6 November 2019

## RECORD AND RESPONSE TO SUBMISSIONS Ivanhoe Estate, Macquarie Park - Stage 1

Extracts from Government agency and authority submissions and submissions from the general public received in relation to SSD 8903, and a response to each of these matters, has been outlined in the **Table below**.

PL01 A1 ROOF PLAN
1:200@A1

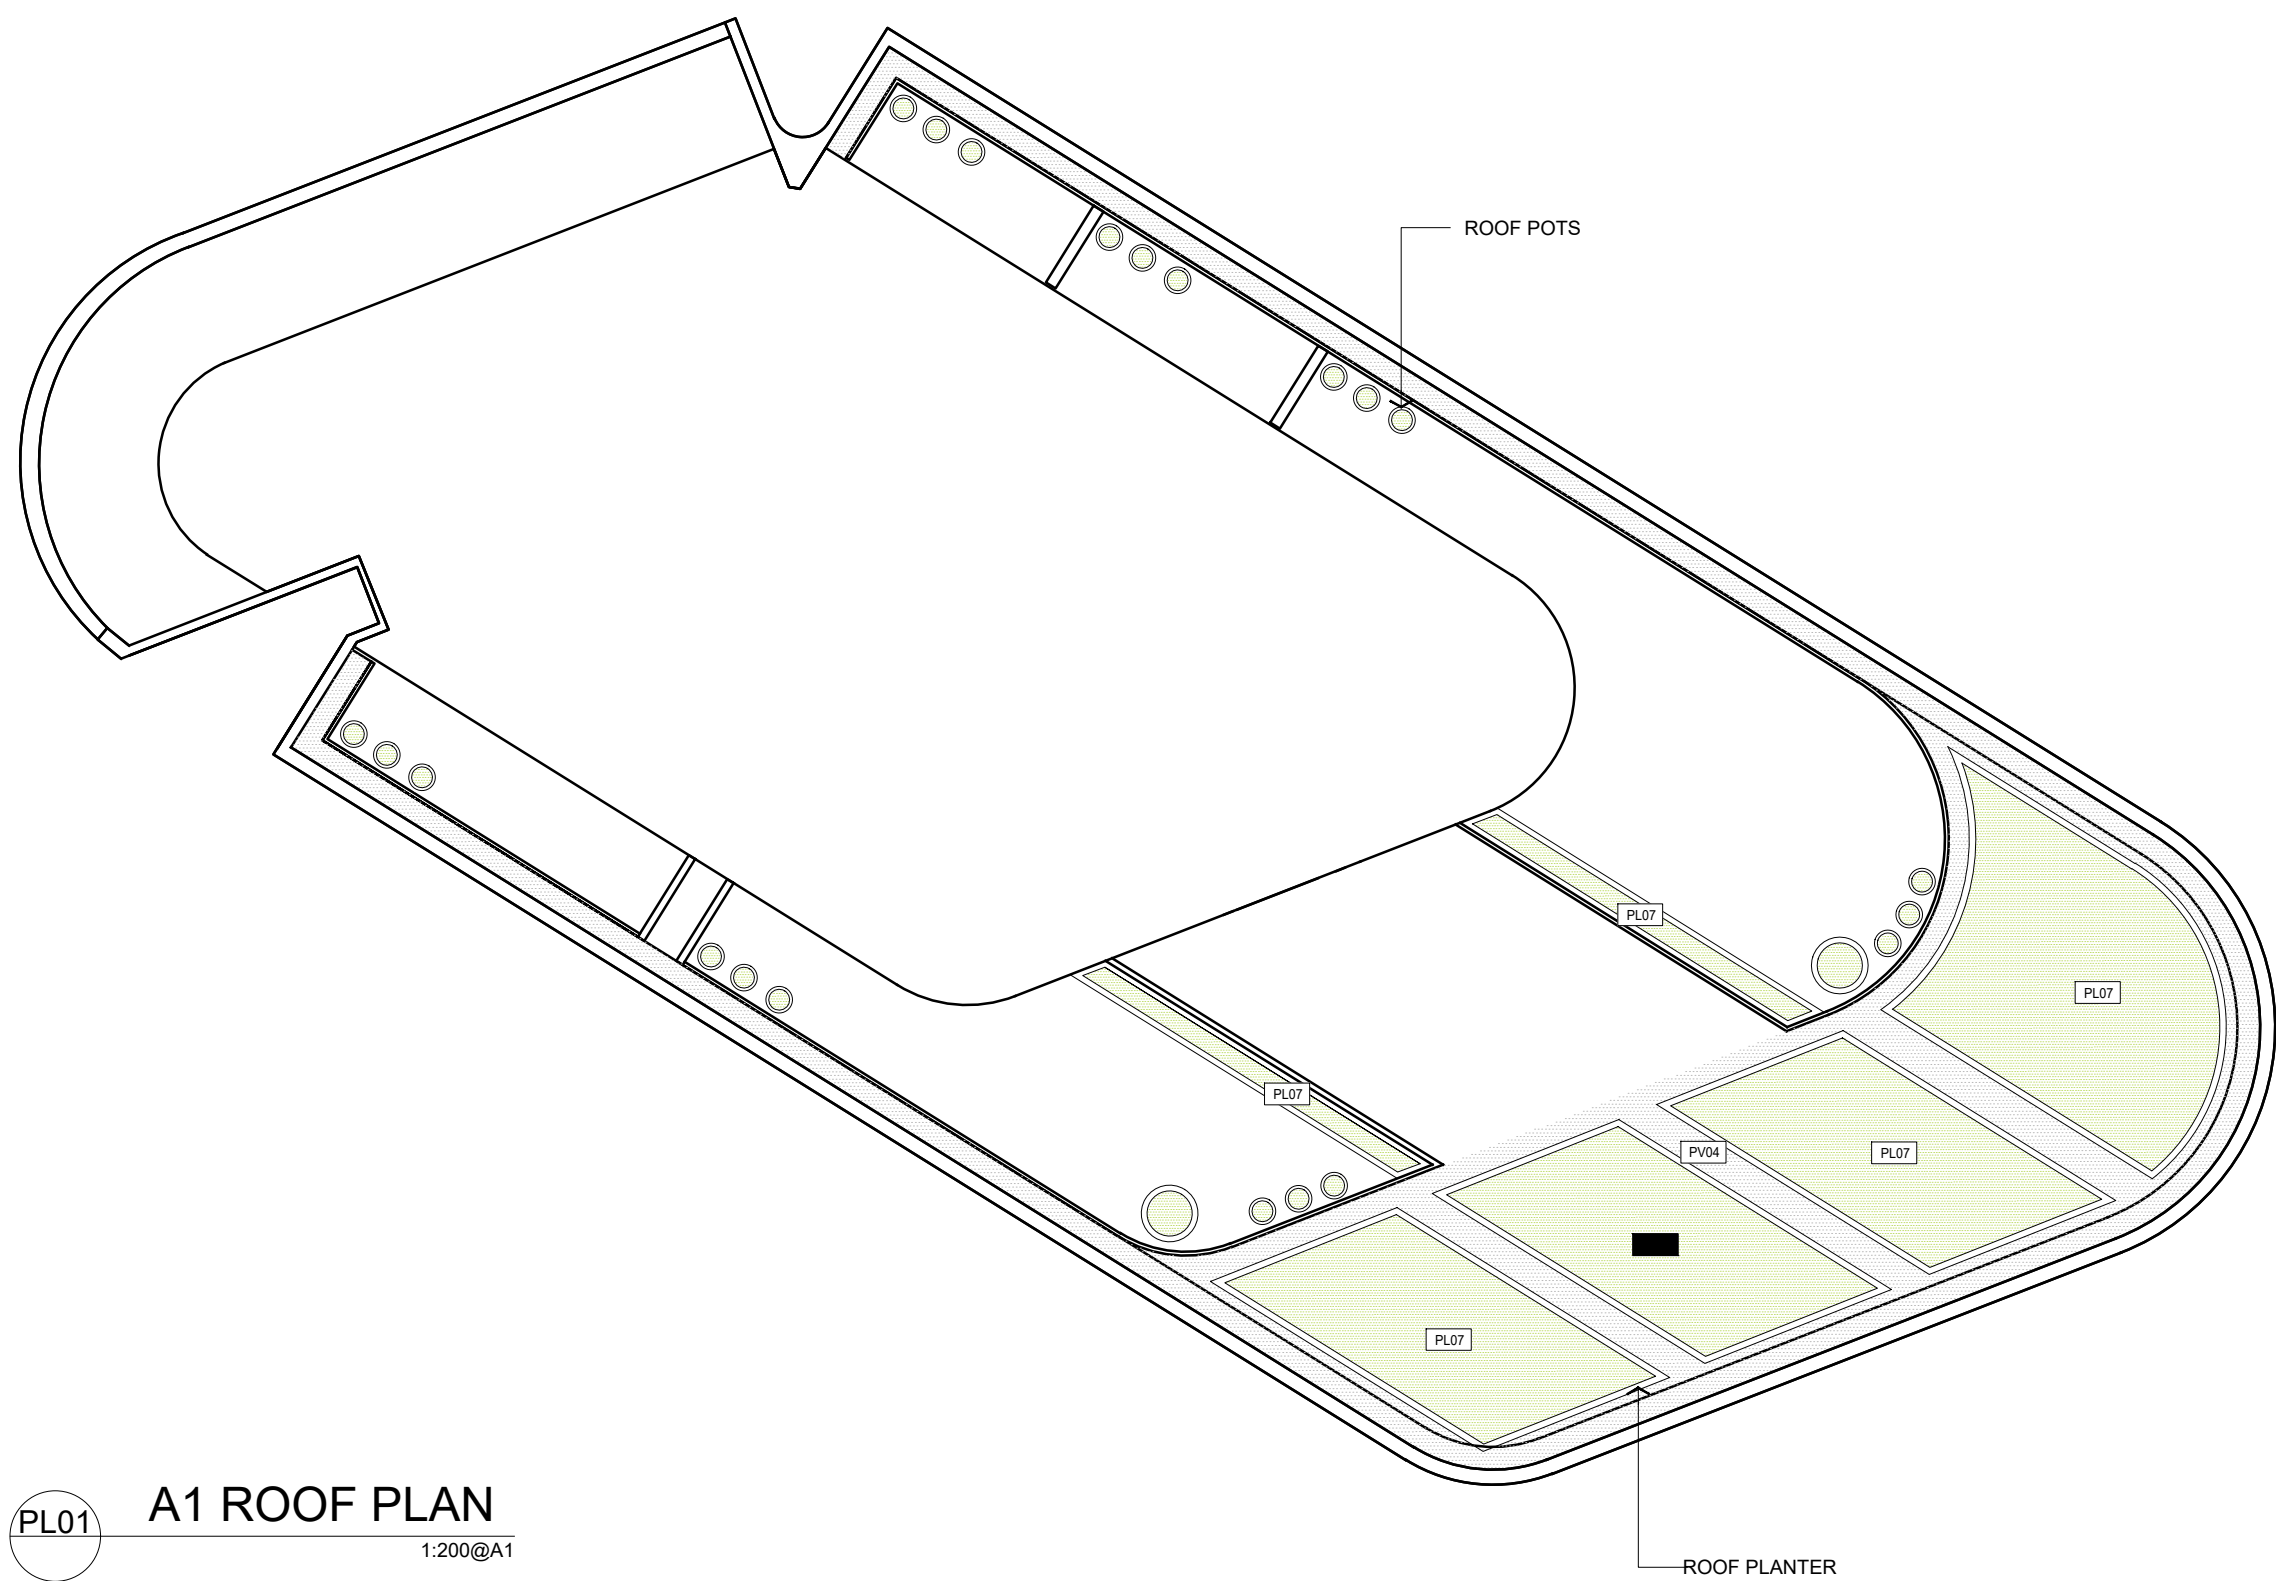
<p>Investigate the provision of roof top communal open space and/or other form of communal space (internal and/or external) within Building A1. The provision of larger private open space for apartments in Building A1 should also be considered.</p>	<p>Building A1 is not capable of being provided with communal open space either at Ground Level or the rooftop of the building. This design outcome is influenced by, and considered to be appropriate, in view of the following:</p> <ul style="list-style-type: none"> <li>• The provision of communal open space is entirely consistent with the framework established under the Ivanhoe Estate Design Guidelines. These guidelines recognise that not all lots are capable of delivering communal open space, and as such it proposes a balanced approach to communal and public open space whereby greater than 25% of the Estate will be delivered as open space despite minor deficiencies within individual stages. The residents of Building A1 will be in short walking distance of the Village Green.</li> <li>• Ground Floor communal open space is not capable of being delivered on the site as Building A1 accommodates a large landscaped external terrace to be used by the childcare centre, which occupies the Ground Floor and provides other benefits such as an activated street frontage and access to services for future residents, workers and visitors to the Estate.</li> </ul>

01 C1 PRIVATE OPEN SPACE
1:100@A1

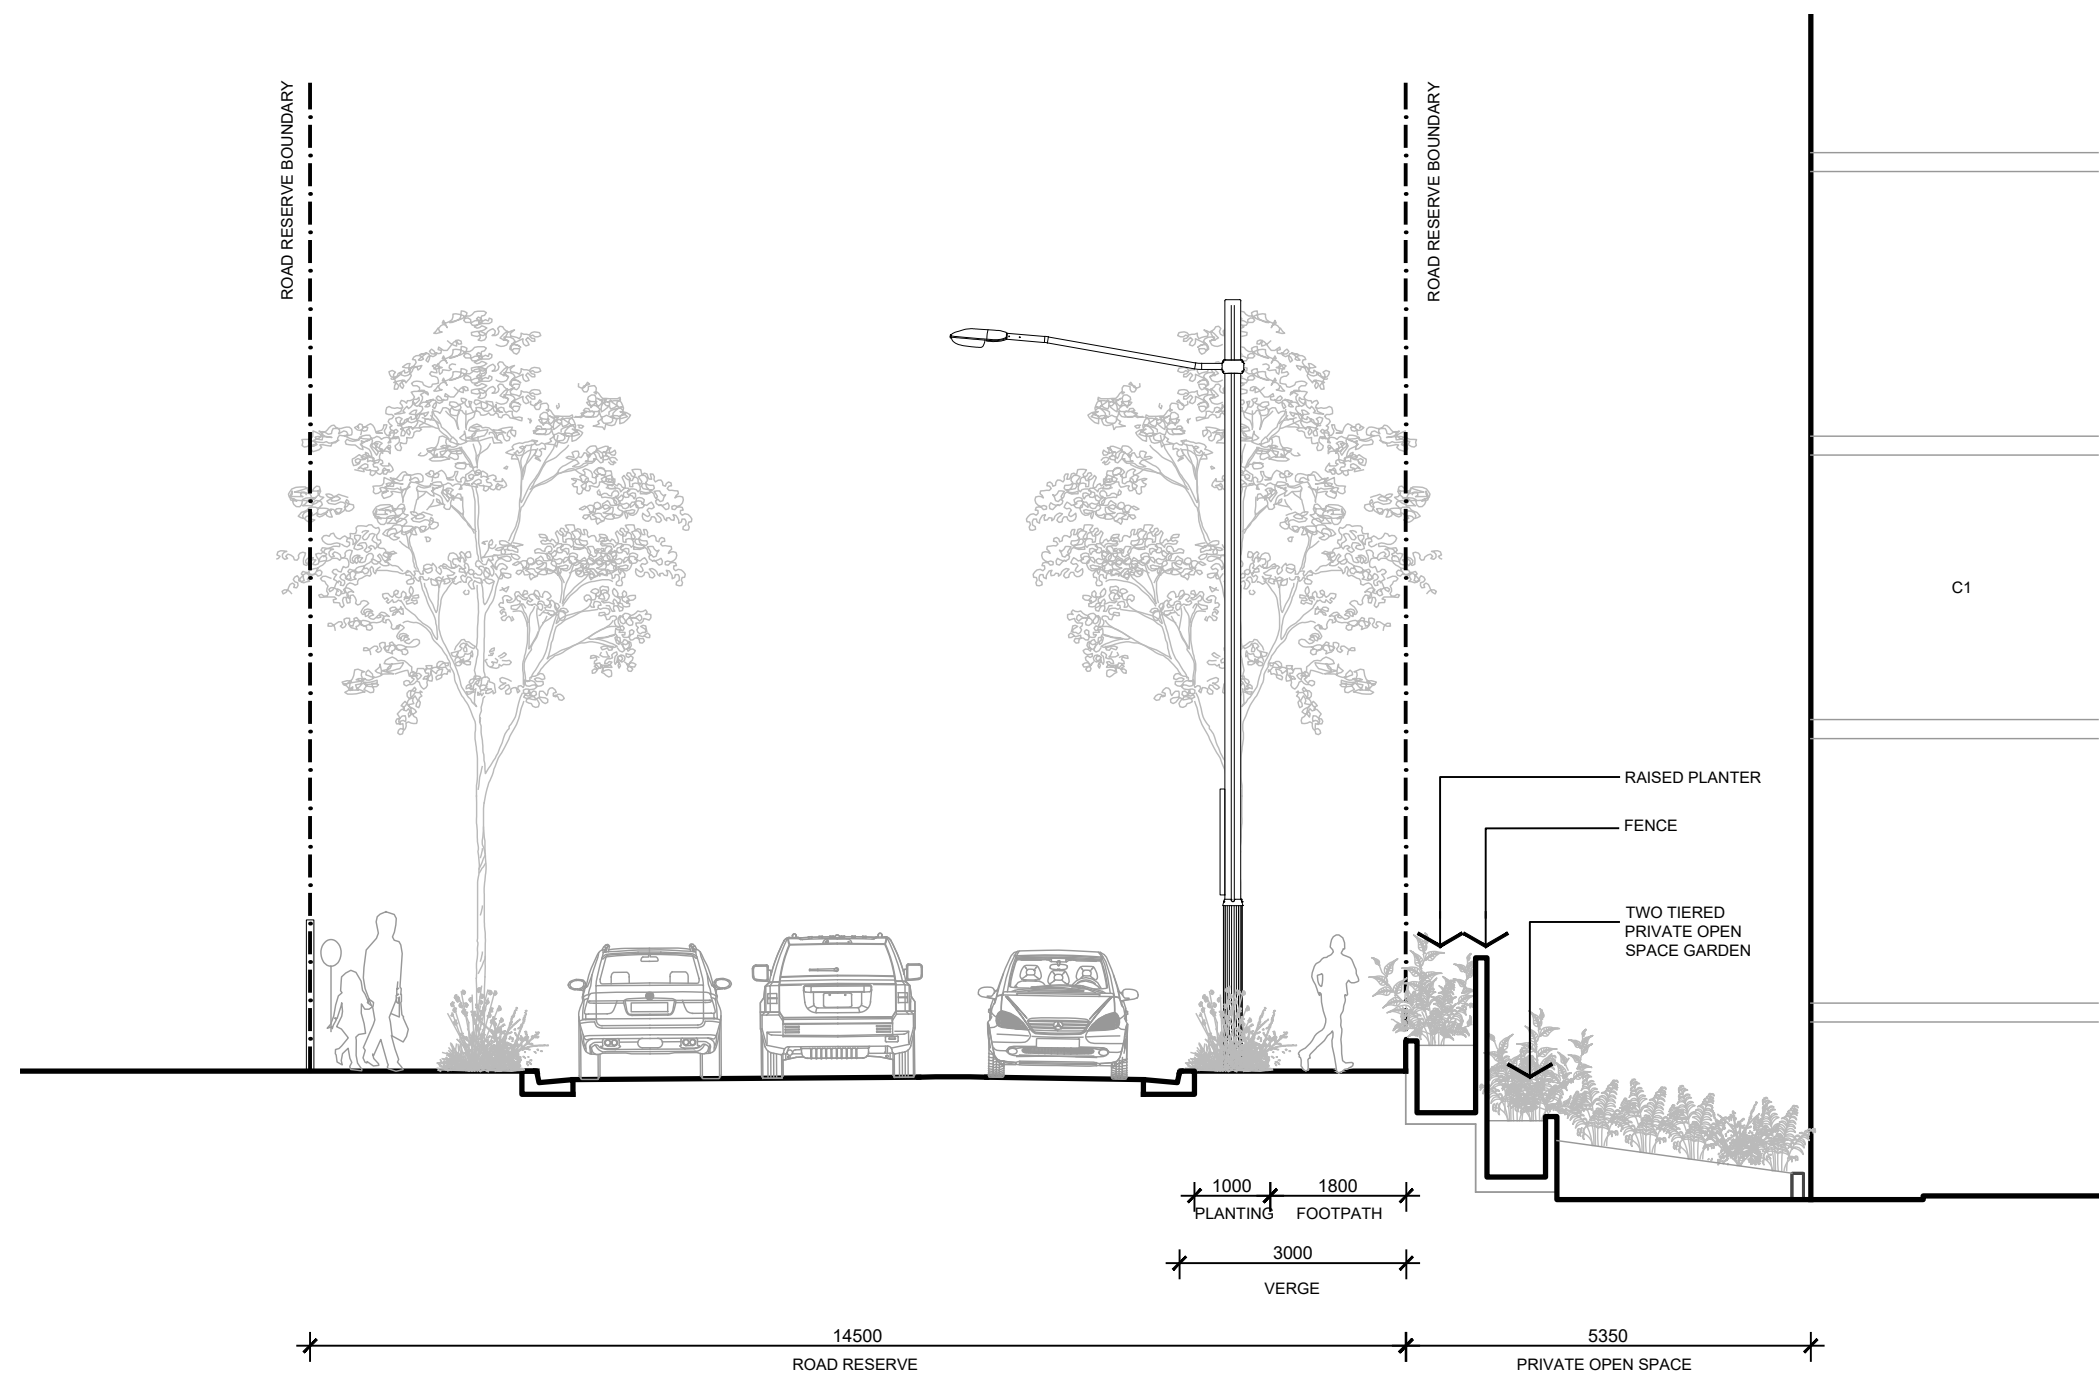
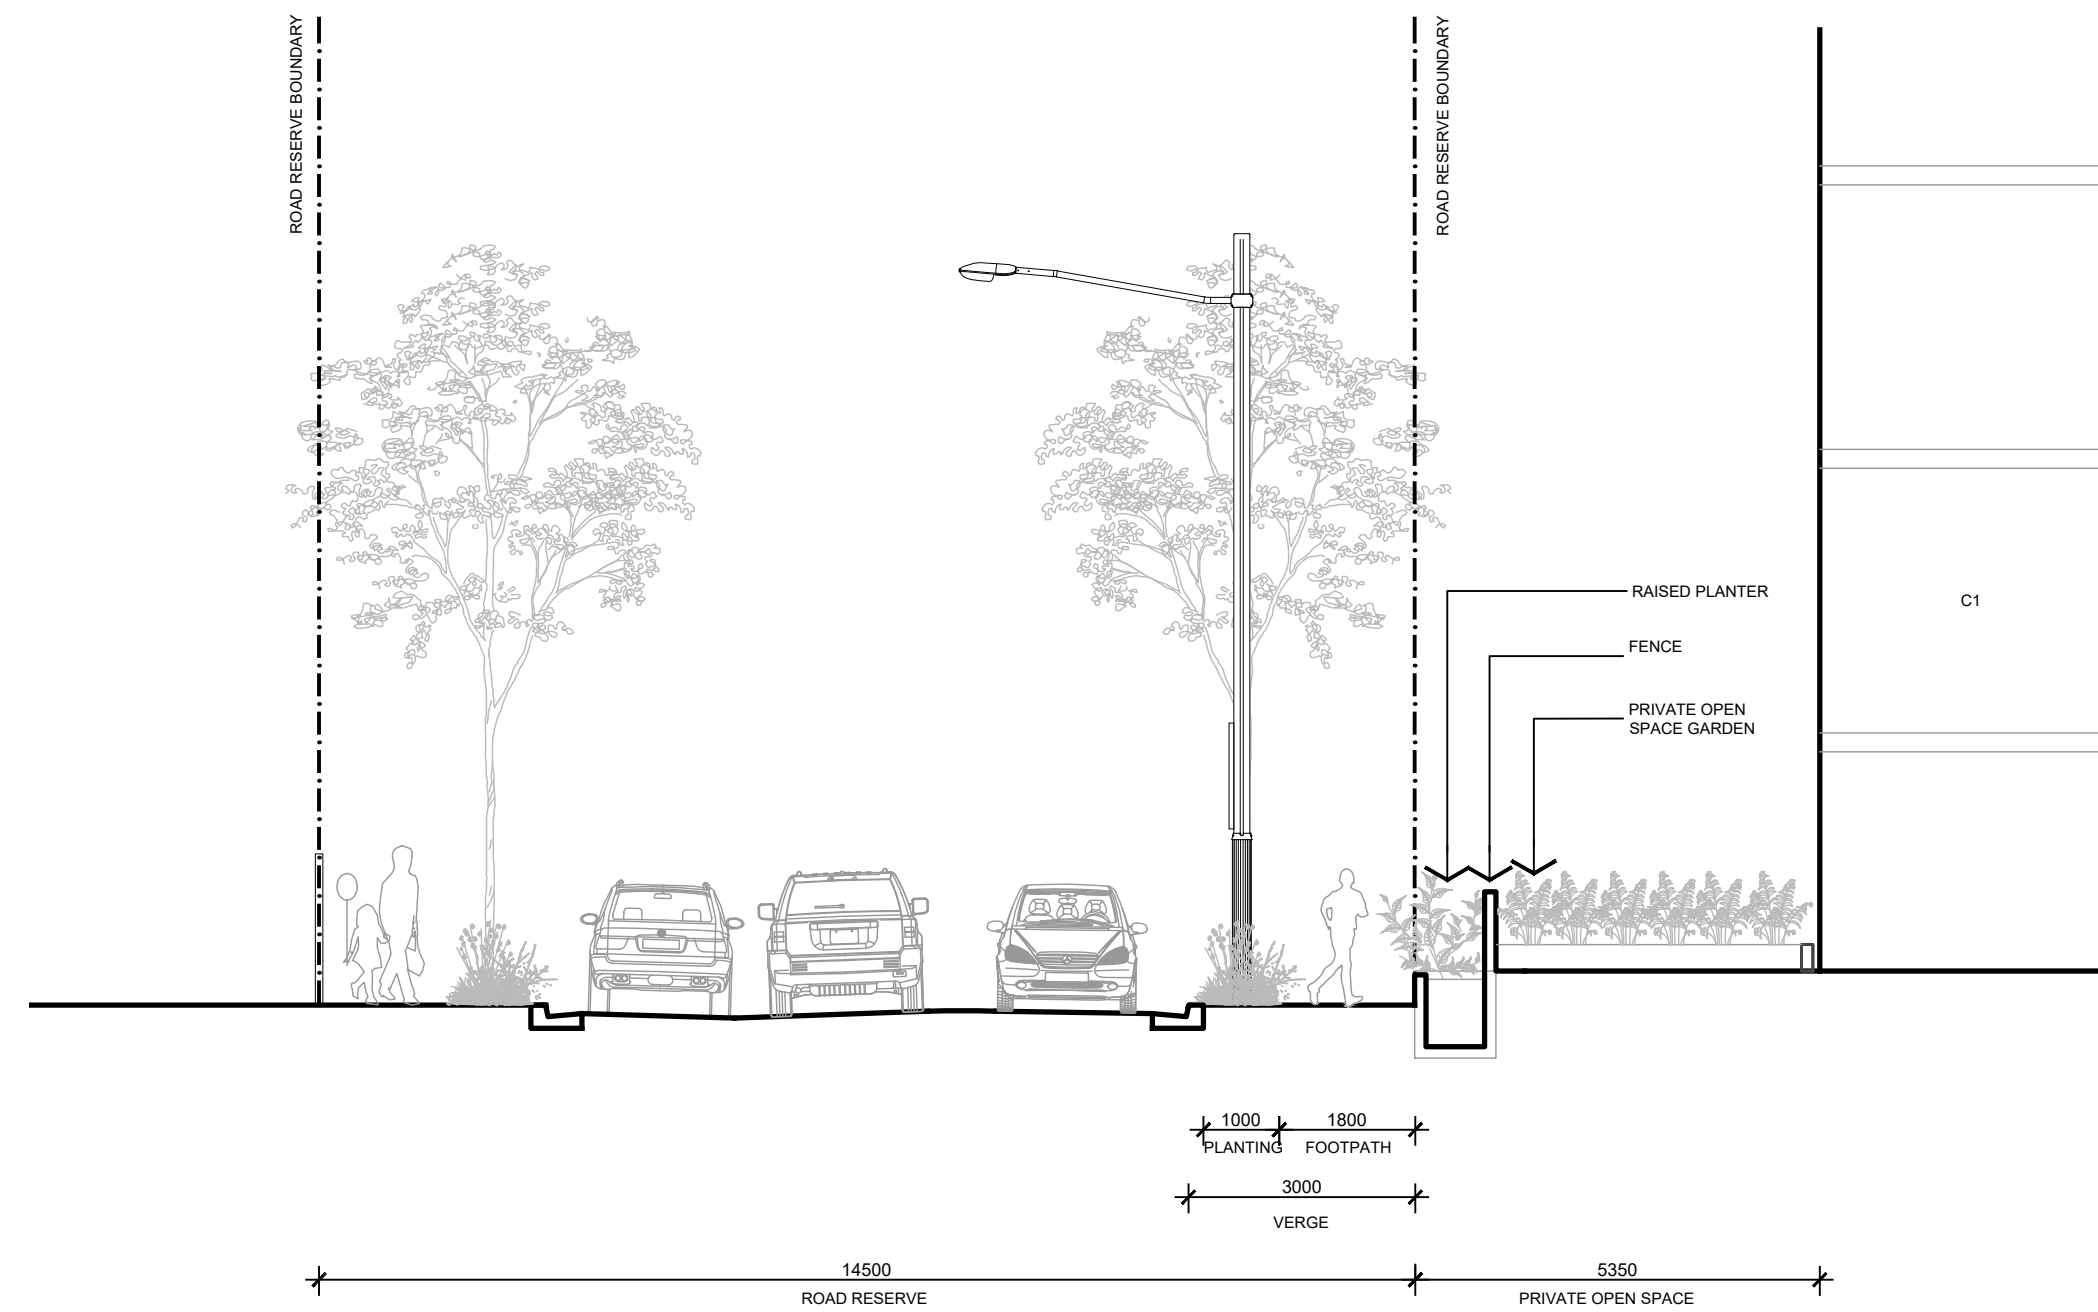
<p>Confirm how many balconies within Building C1 do not satisfy the ADG minimum size recommendations and demonstrate the useability of these balconies, noting the relevant size of the apartment and corresponding need for increased balcony sizes for larger apartments.</p>	<p>The revised plans and SEPP 65 assessment prepared by Candalepas Associates (<b>Appendix B</b>) demonstrates that minor design changes have been made to the apartments within Building C1 to ensure that the area of all balconies comply with the ADG requirements. Whilst these balconies achieve the minimum prescribed areas, the depth of the balconies vary to provide façade articulation and privacy as detailed in Figure 56 of the Stage 1 EIS. This means that a small percentage do not achieve the full required depth across the entire balcony area. However, these balconies remain functional and provide appropriate amenity to residents as detailed in the additional diagrams prepared by</p>

Extract	Response
	<p>Candelas Associates (extracts included below) which demonstrate that the irregular shaped balconies can accommodate planting and outdoor seating.</p> 
<p>Clarify why the Building C1 green roofs are not designed to be accessible to residents.</p>	<p>The provision of communal open space is entirely consistent with the framework established under the Ivanhoe Estate Design Guidelines, and comprises 28% of the site area in accordance with the requirements of the ADG. The ground level communal open space receives a minimum of 2 hours of sunlight to 50% of the space during the mid-winter and is of a high-quality design that will benefit the recreation and socialisation of residents. The residents of Building C1 will also benefit from private balconies for each apartment and the new Village Green opposite, and as such it is proposed that the C1 building roof will operate as a greenroof and not accessible gardens.</p>
